Date: 13 November 2017

APPLICATION CONSULTATION RESPONSE

Application Number:	3/2017/0357
Location:	Lower Moss Farm, Lower Ln, Longridge, PR3 2YH
Grid Ref:	361015/436658
Proposal:	Development of site for the construction of 10 no. holiday units

PROPOSED SITE PLAN	
Site: Lower Moss Farm Lower Lane Longridge	
Client: Rainford	
Date: 1.04.17	Scale: 1:500 @ A2
Project No: RAI/10 Dwg 02	Drawn: KH
Amendments:

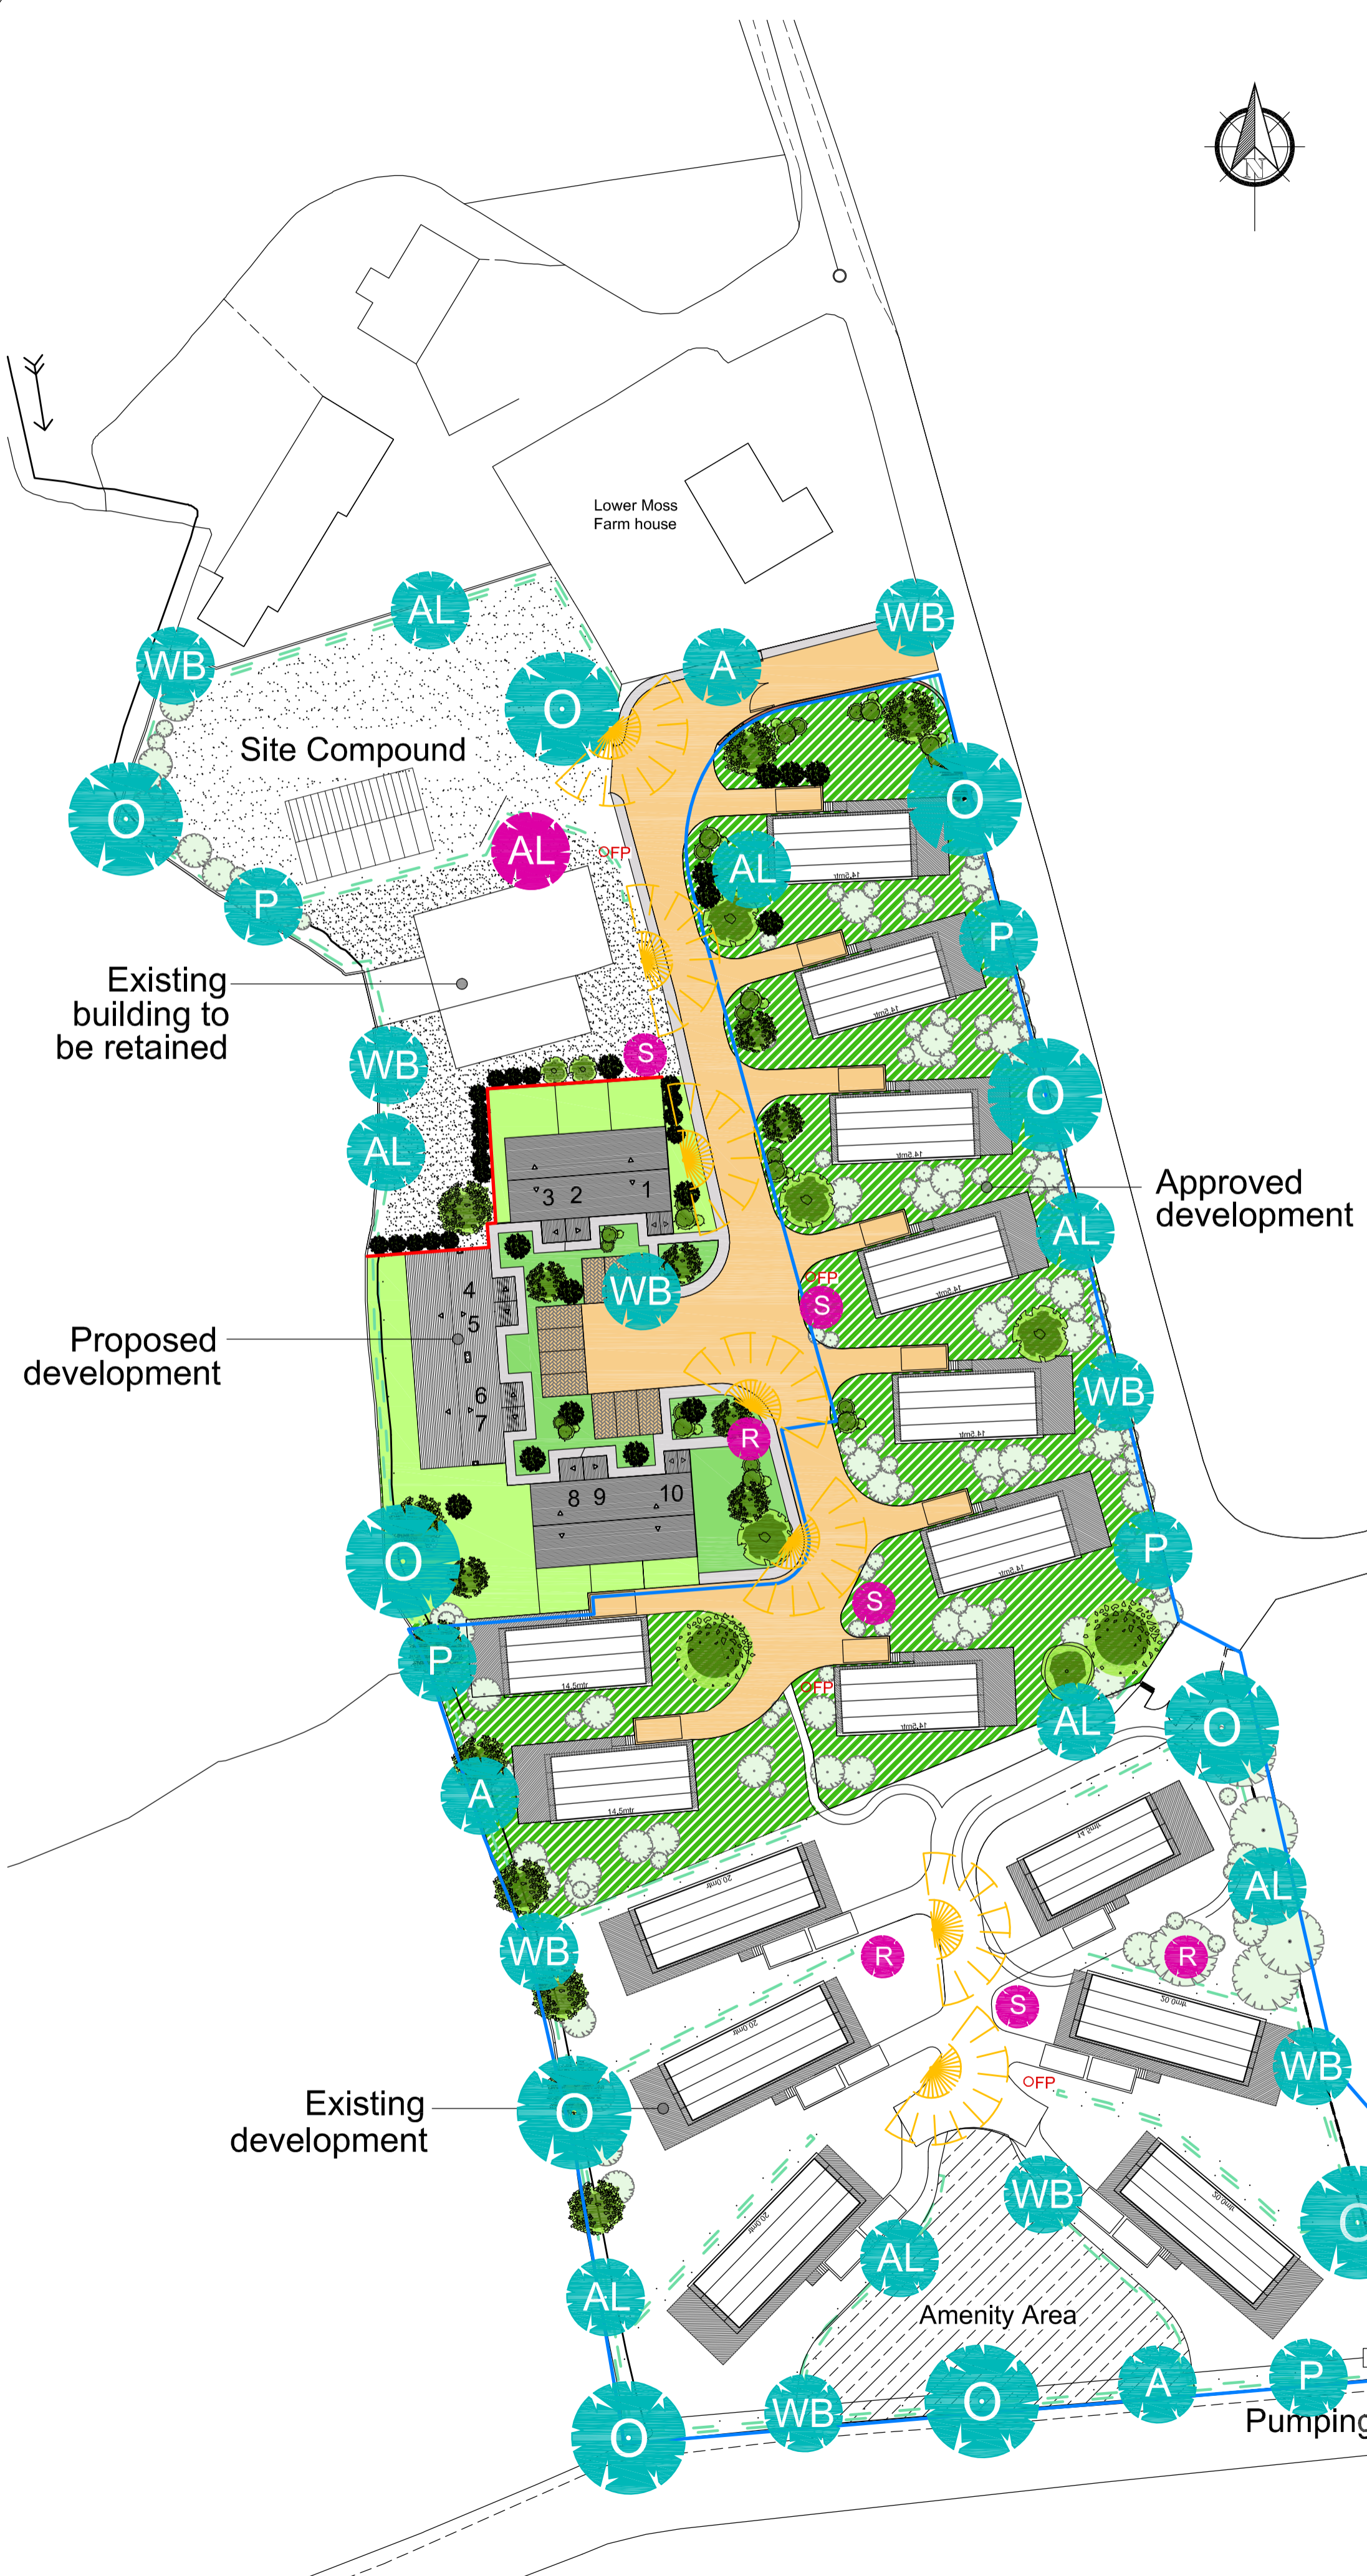
The proposals indicate that the applicant intends to discharge surface water into the open watercourse at the west side of the development site.

- Carry out studies of the existing culvert/watercourse condition and capacity;
- Undertake an examination of the downstream condition and implications of the development proposal, and;
- Restrict discharge rates so that the peak runoff rate from the development to the ordinary watercourse for the 1 in 1 year rainfall event and the 1 in 100 year rainfall event should never exceed the peak greenfield runoff rate for the same event.
